## Greenwich Community Association Inc

1 April 2019

**State Significant Development SSD 17\_ 8699**  
**Staged redevelopment of Greenwich Hospital (Concept Proposal)**

MARK-UP OF S04/T3 TO SHOW ERRORS/OMISSIONS

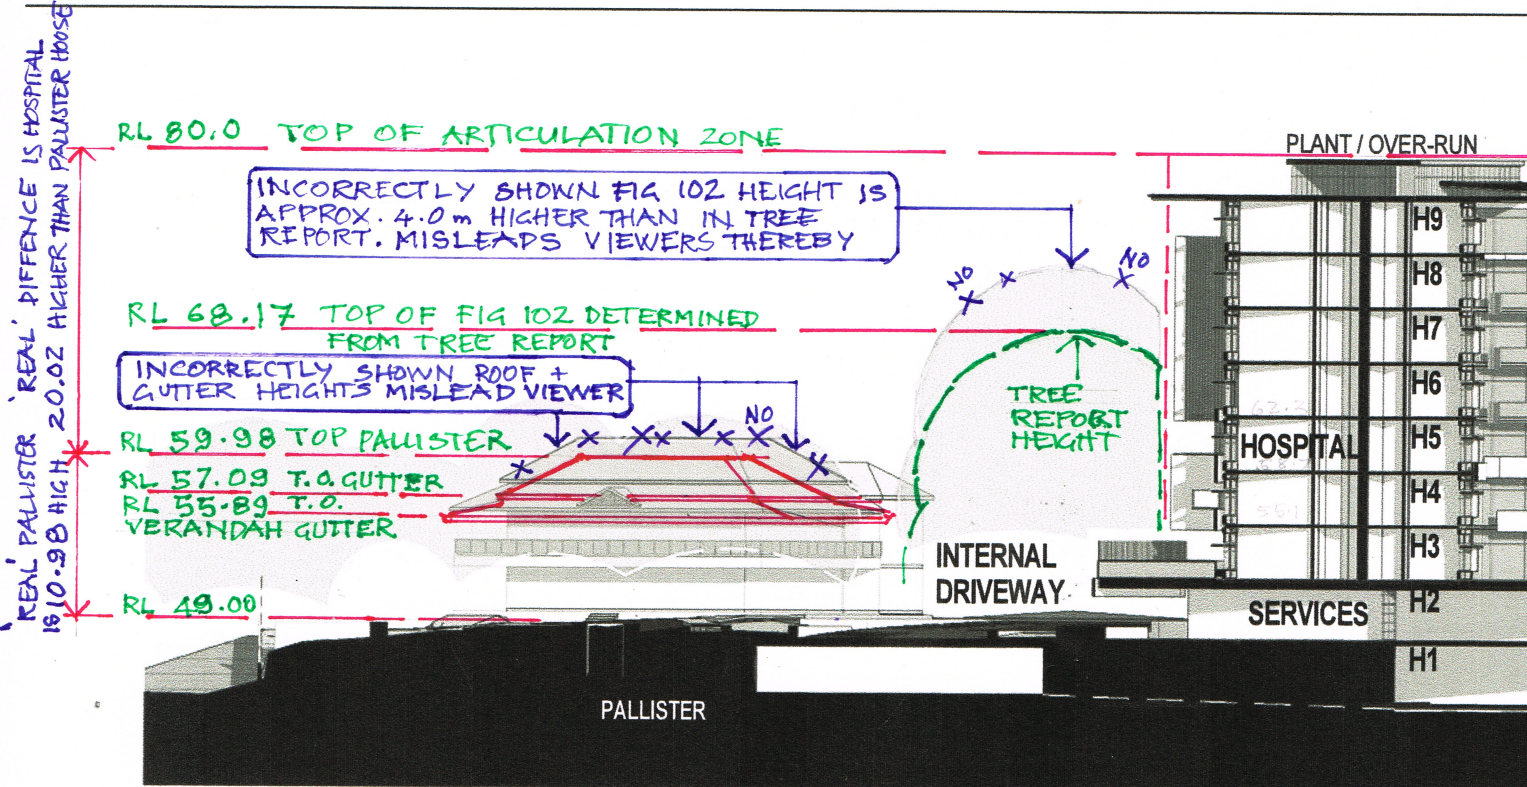
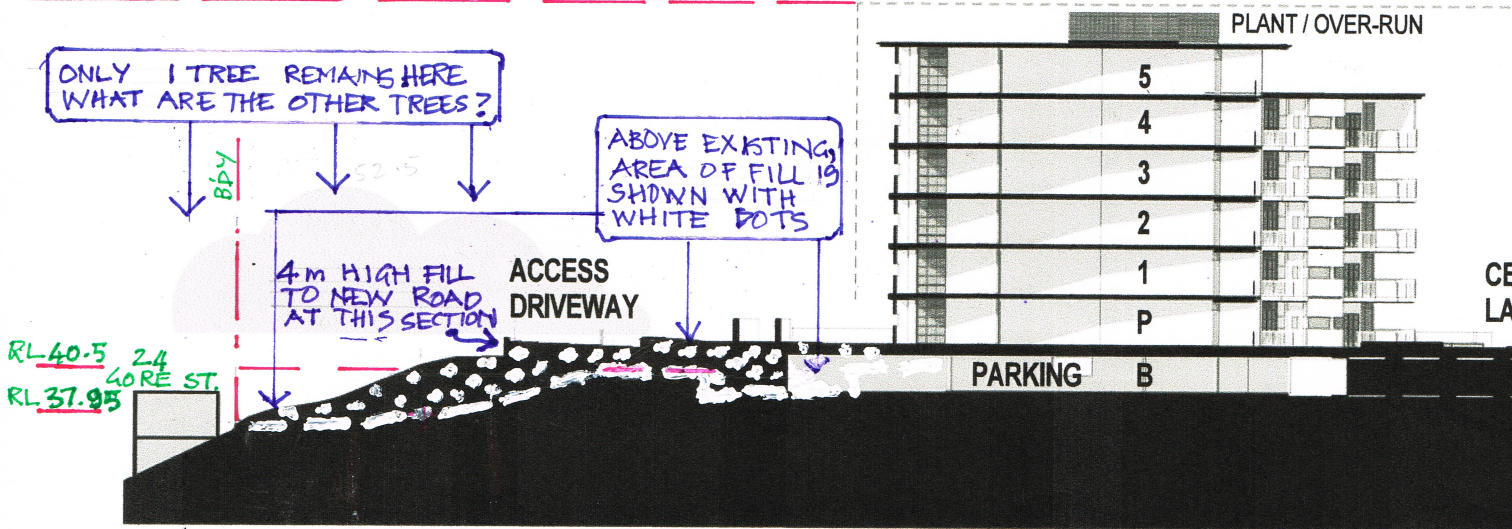
**3. The apartment building on the southern portion of the site disrupts the significant natural landscape features of the environs**

The proposed development will extend significantly above the trees and bushland that form the backdrop to Bob Campbell Oval. The height and presentation of the building will dominate the bushland setting – the development is completely out of character with the residential developments along the ridge above Bob Campbell Oval that all blend with their bushland setting.

**The design of the proposed apartment building on the southern boundary is inconsistent with Objective H1.5 of the Lane Cove Development Control Plan and should be revised.**
